82C 39/08/22

1. *Please provide greenfield runoff calculations. Not provided, please provide. I note you have an impermeable area of 1.587ha, according to UKSuDS this gives a Qbar rate of 3.19l/s. Please provide justification for your discharge rate, including calculations. SGC 30/08/21 -- Greenfield runoff calculations provided within re-submission, please refer to 1103-20079_RePH2-Dev Area.pdf. In addition to this, we would like to add that the RCF Design Flood Risk Assessment (U1260/FRA 1.4 dated 08/09/2020) states that post-development flows are not to exceed 13.8l/s (the calculated Qbar rate).*

Tel: 9121 547 1500 Fax: 9121 547 1501 E-mail: mail@binnengate.com	
Scale	A0 @ 1:200
Date	August 2021
File	20079 / dwgs / civils / current
Drawn	CB
Checked	
Drawing	20079 / 117 D

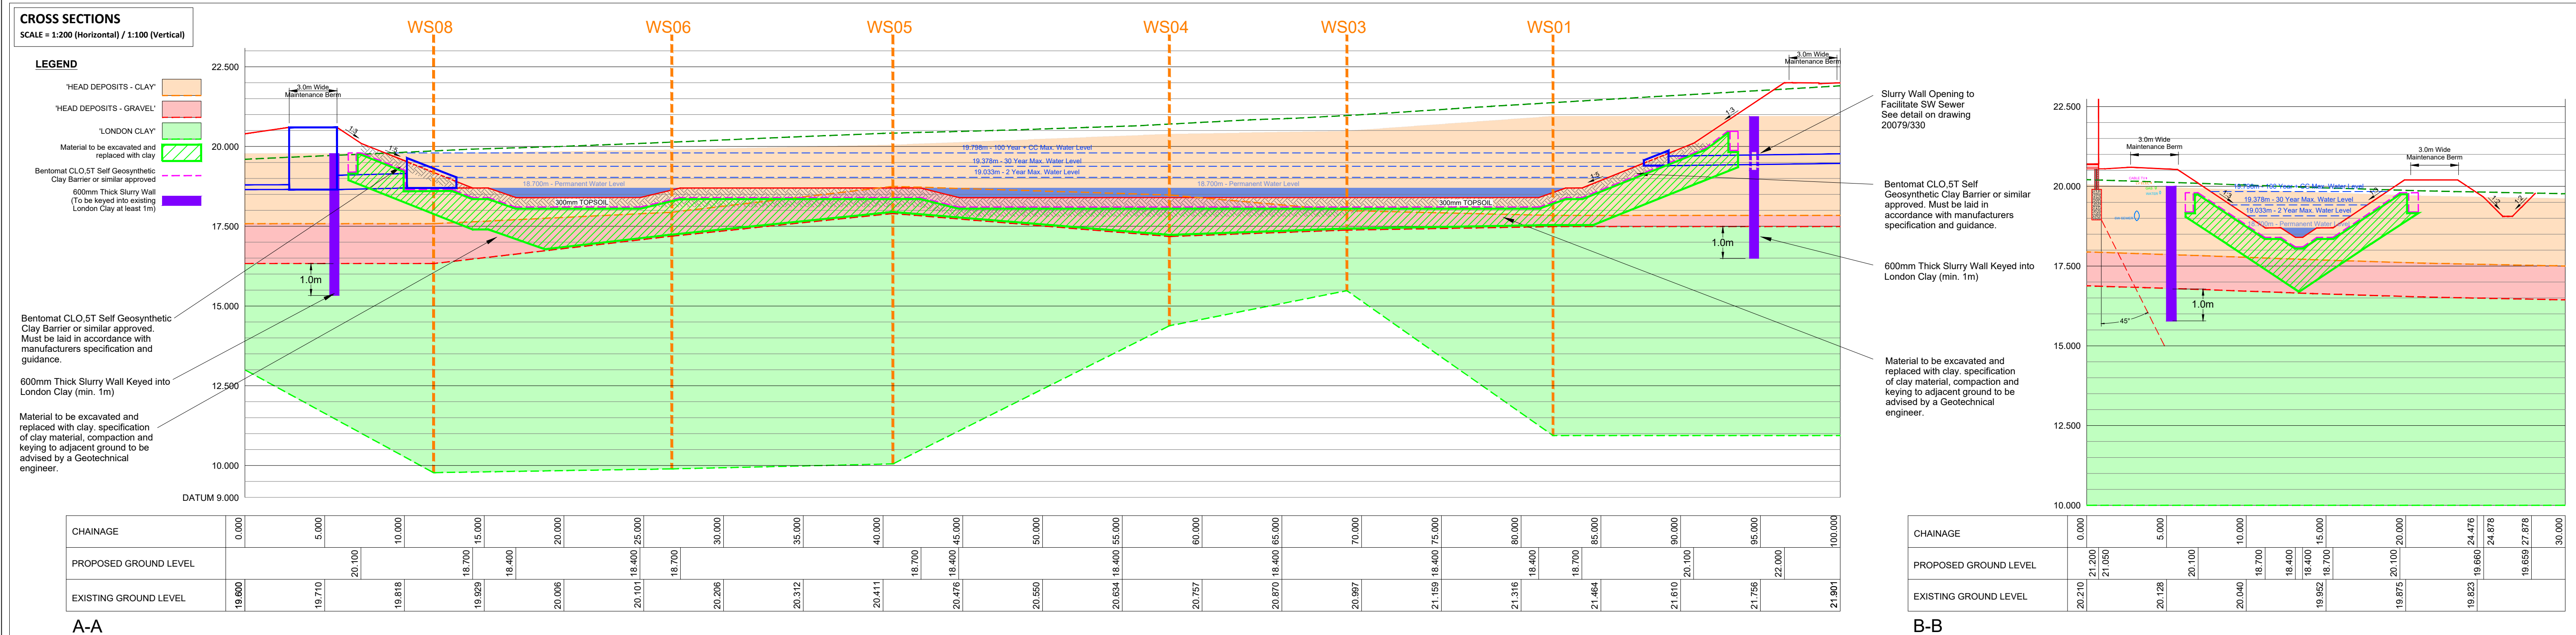
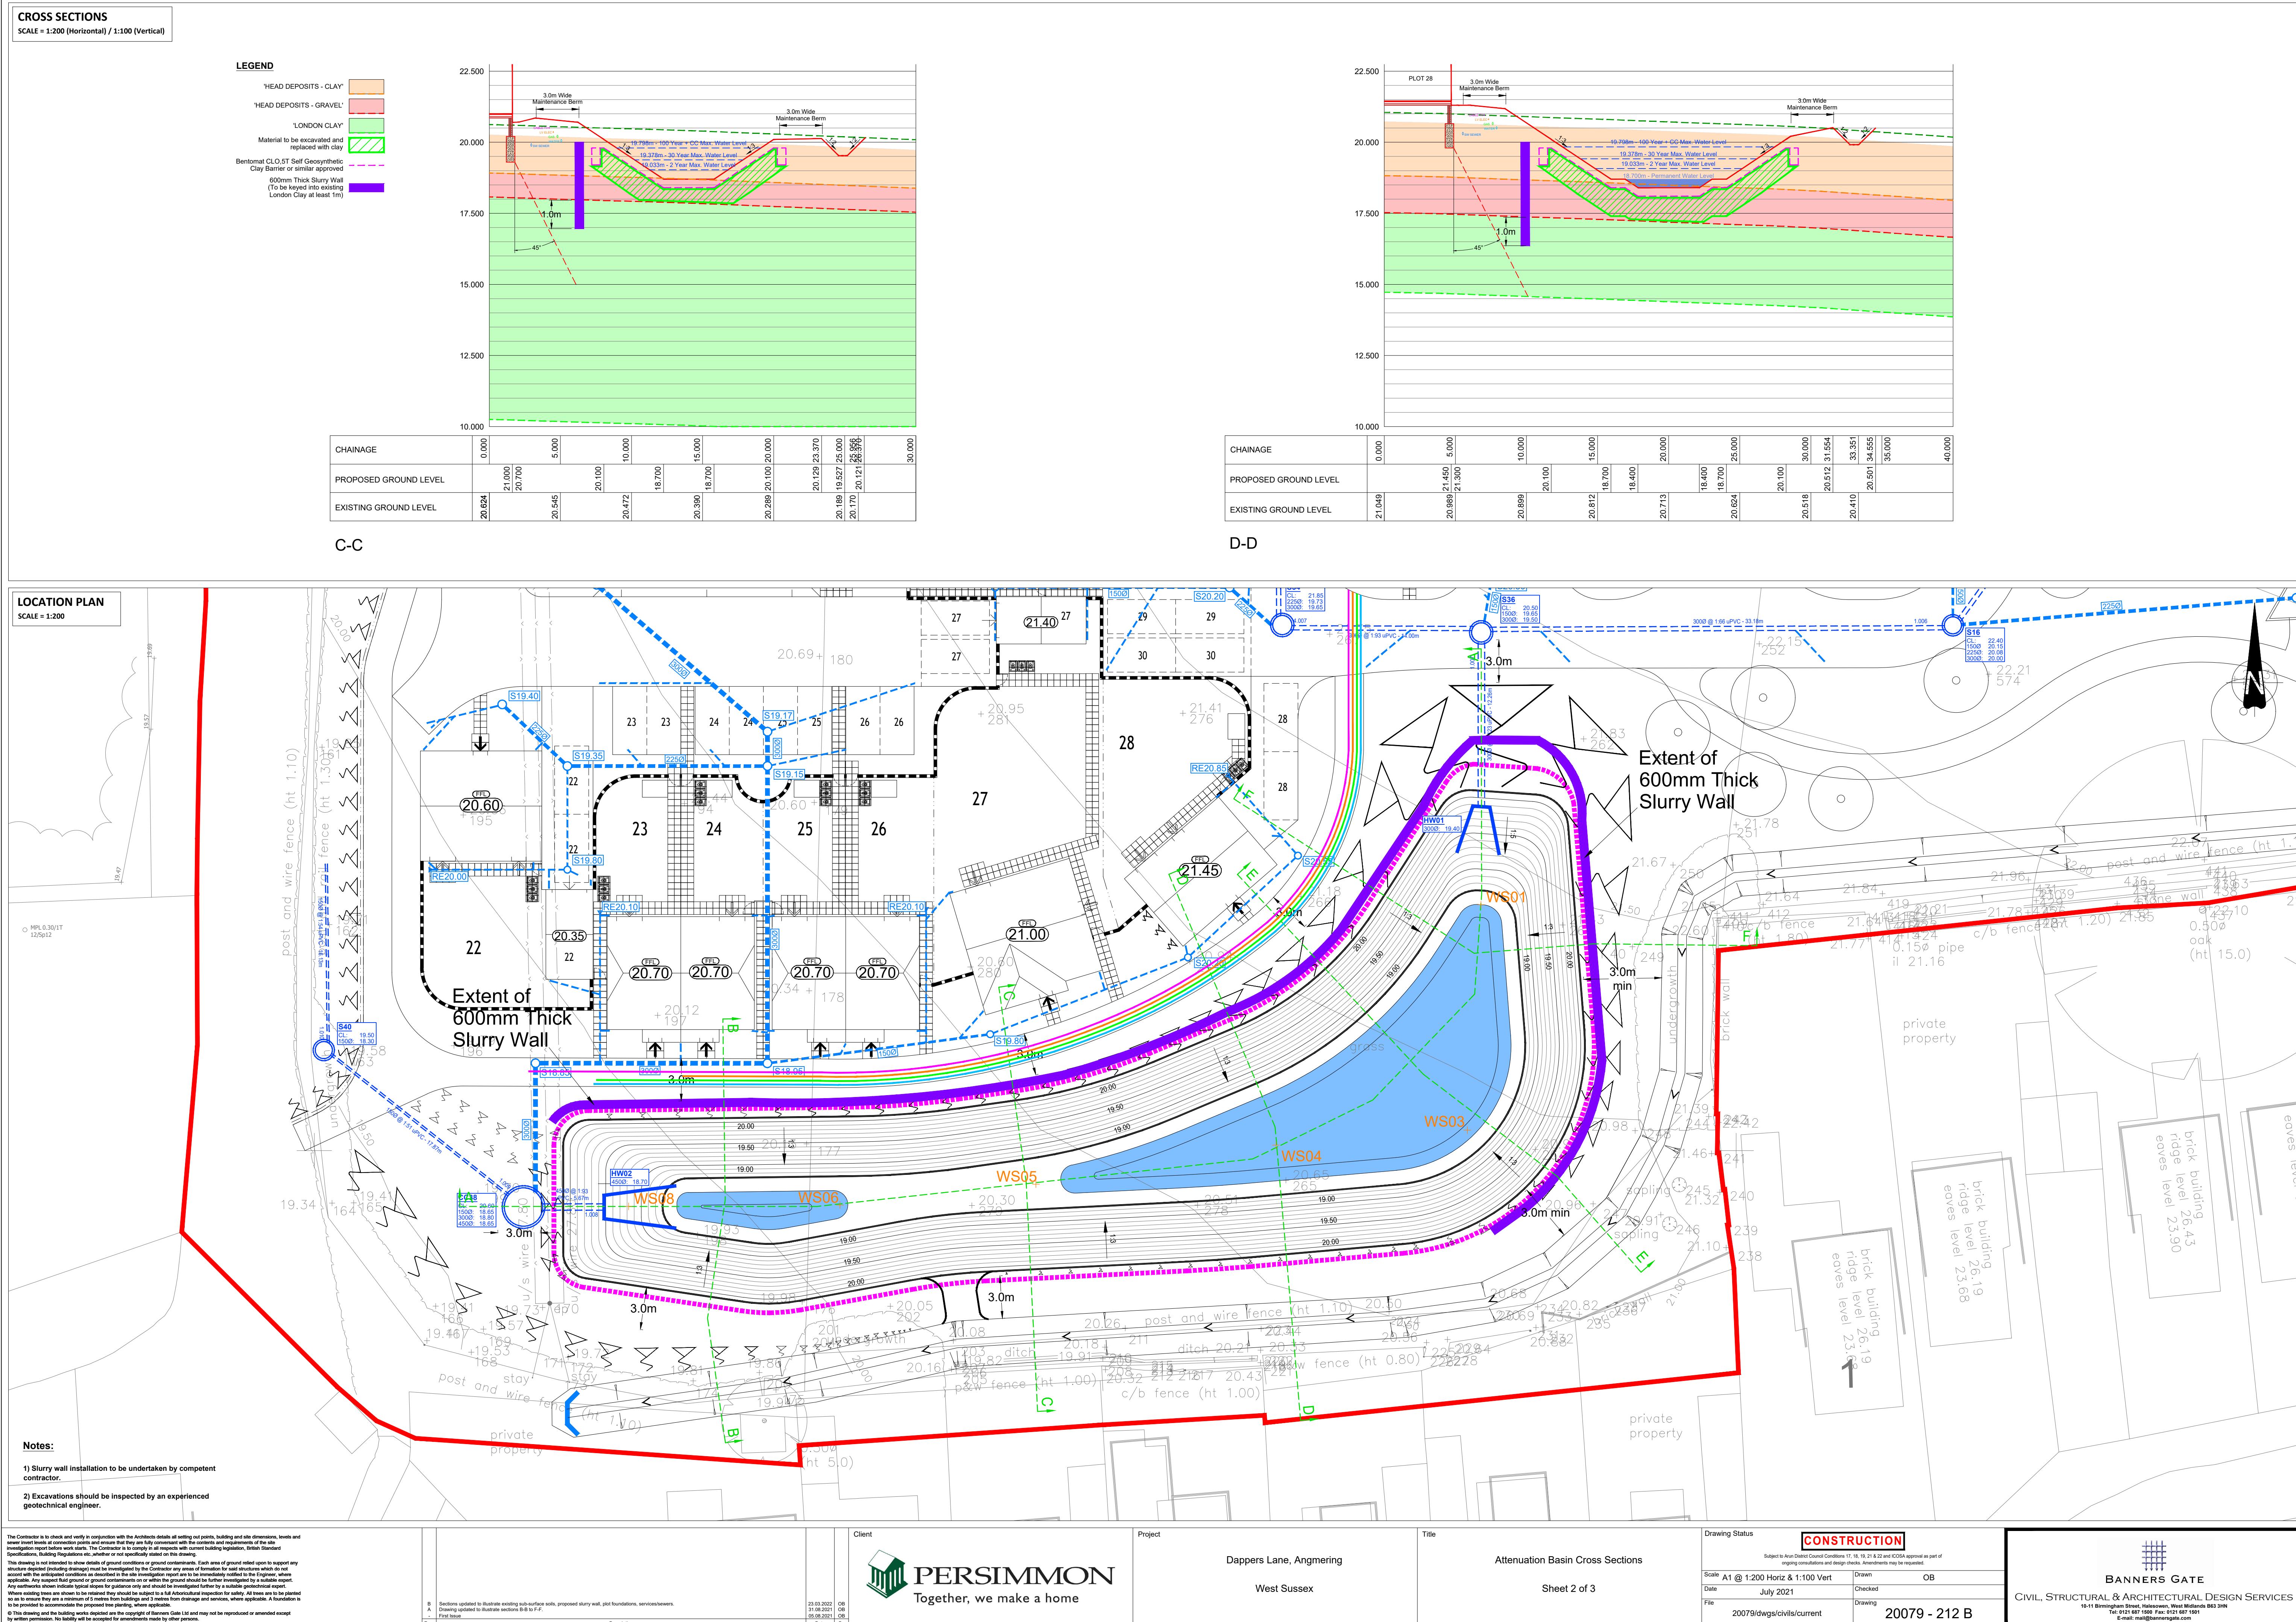
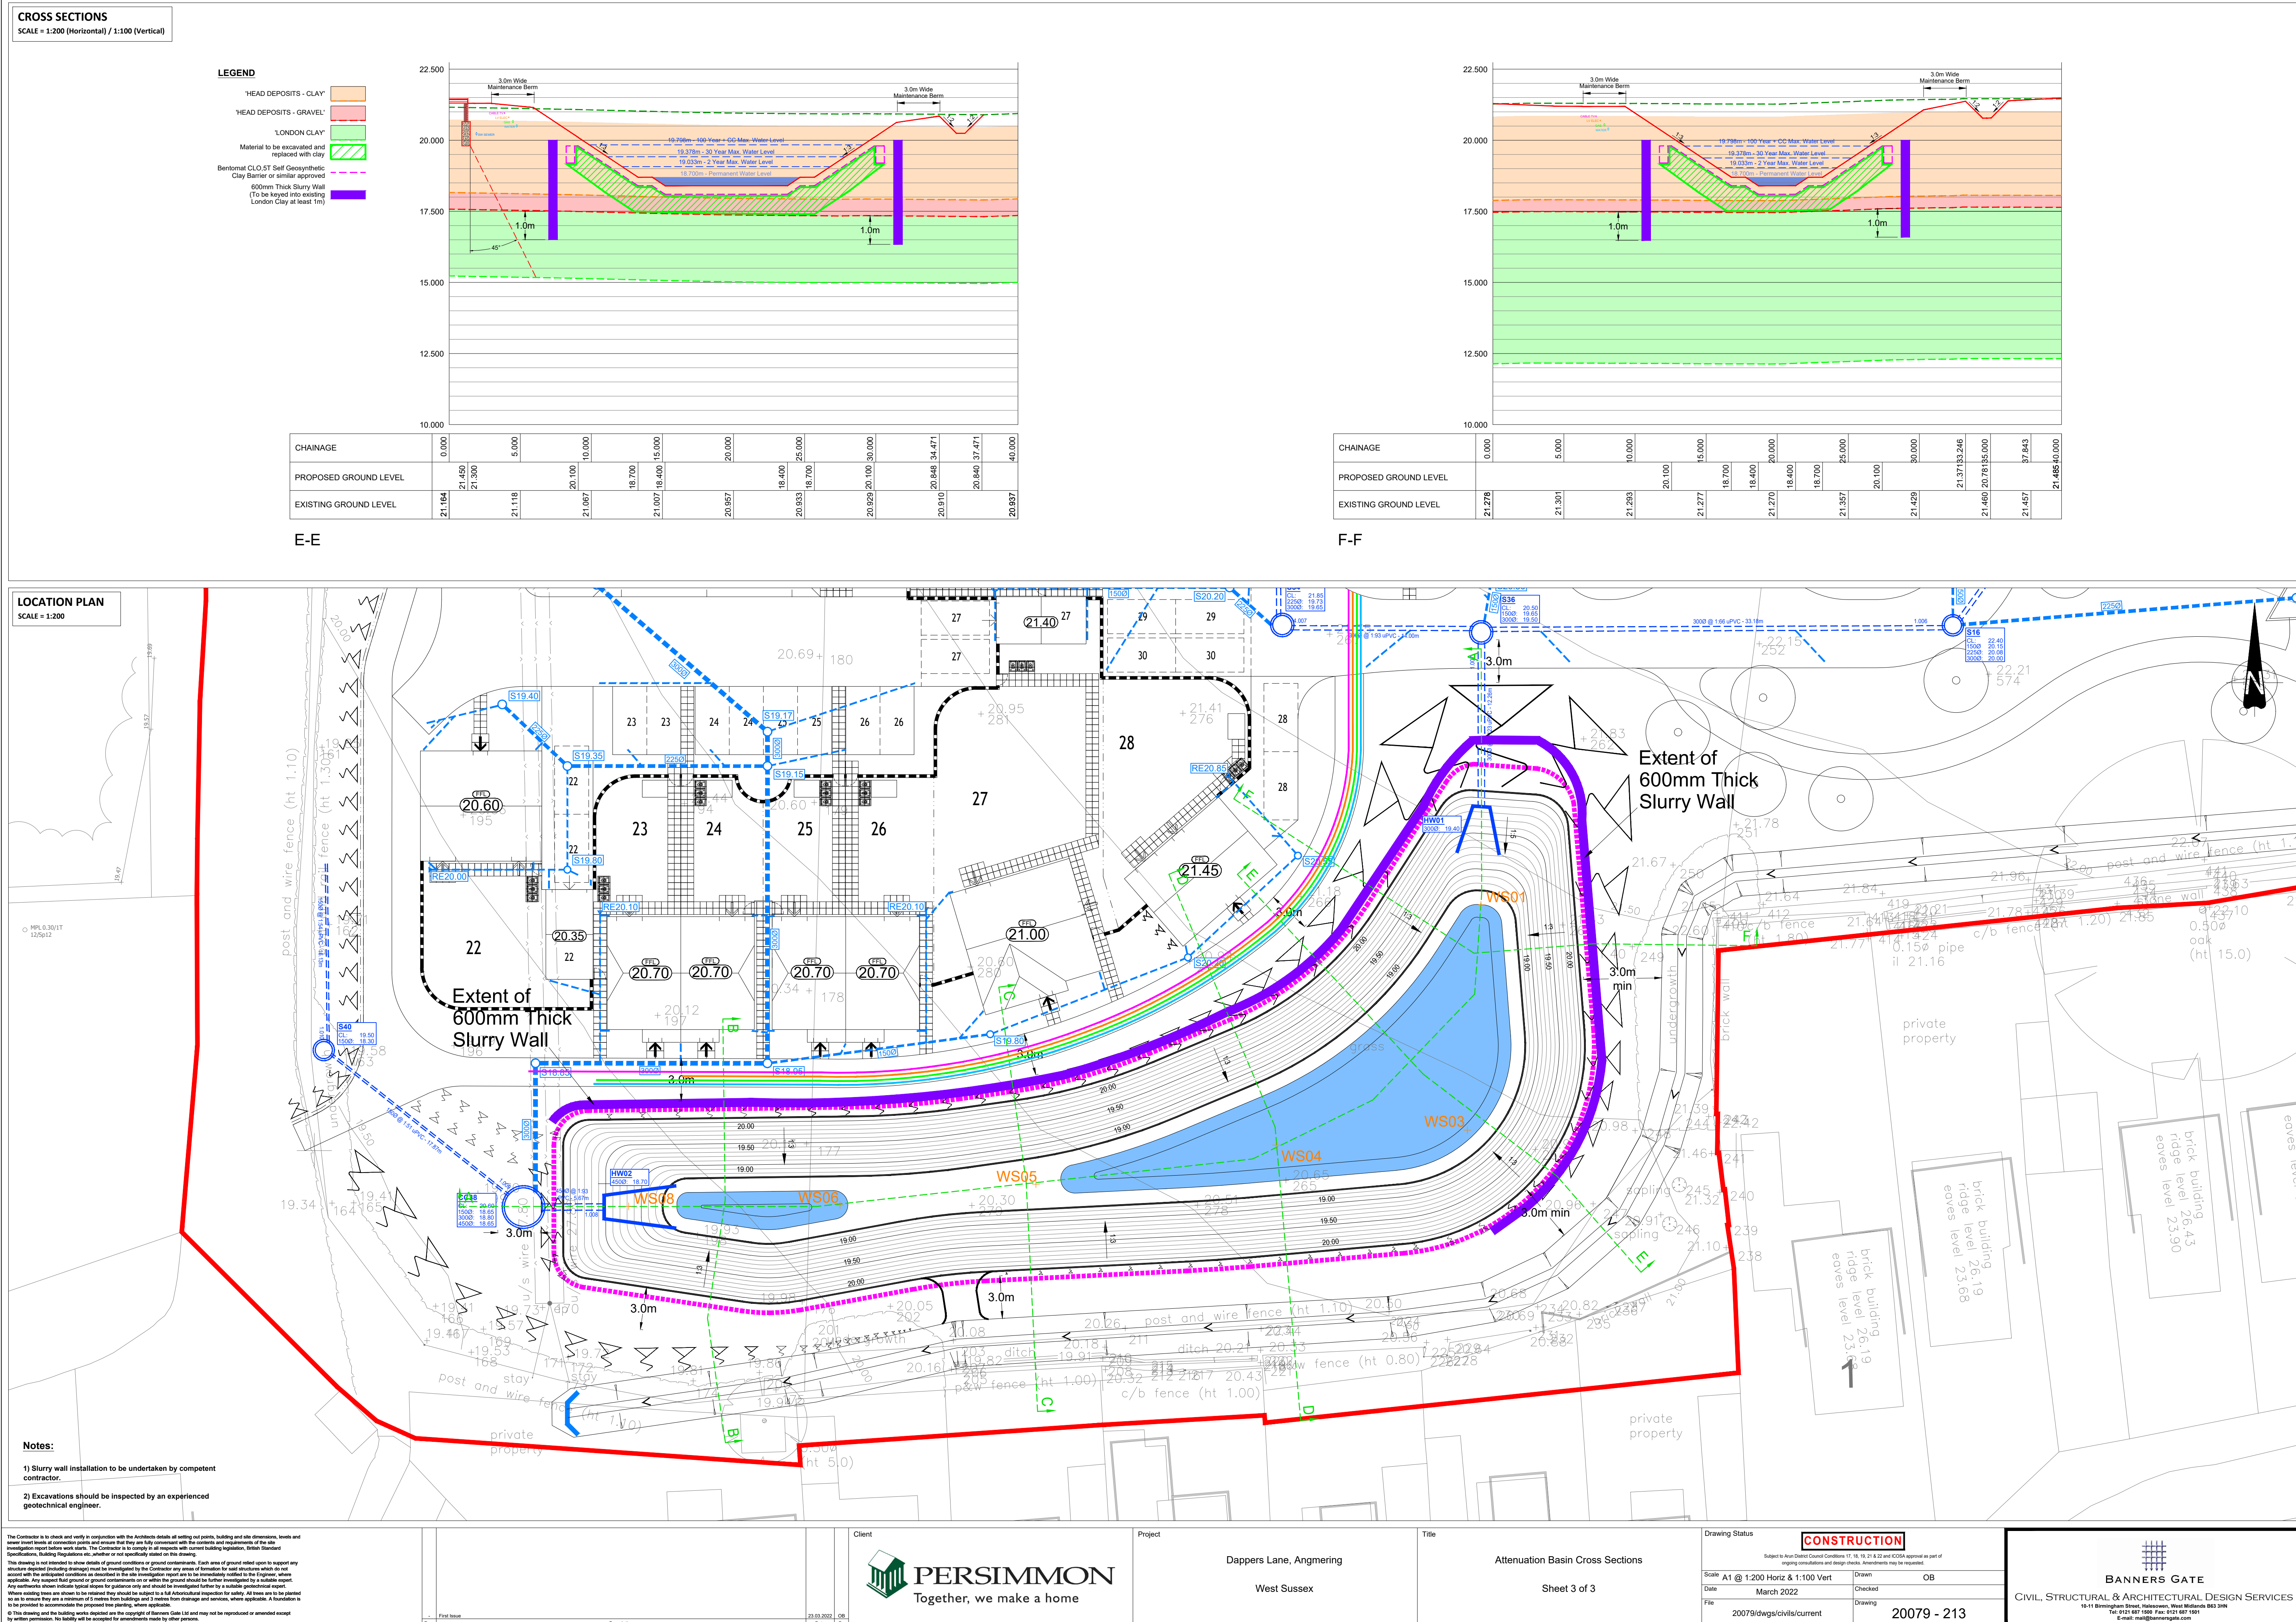
4. *Please provide cover levels on plans. Cover levels of attenuation tanks should be provided on layout plan too. CL of CC12 is incorrectly detailed on plan. Please also see comment 6 below. SGC 31/08/21 -- Cover levels of attenuation tanks added to plan & CC12 cover level corrected, see drawings; 20079/116-118 & 20079/116-118.*

5. *Please detail all pipe diameters and falls on plan. Not provided, please provide for Private Drainage network. SGC 30/08/21 -- All pipe diameters added and falls illustrated, see drawings; 20079/116-118.*

6. *Please detail pipe networks from housing on plan. Cover levels and invert levels, pipe diameters and falls all need to be shown on plan as per checklist requirements. I would also request that more of the network is modelled to evidence that appropriate pipe sizes and falls are being provided and that flooding does not occur. SGC 30/08/21 -- All pipe diameters added and falls illustrated, see drawings; 20079/116-118.*
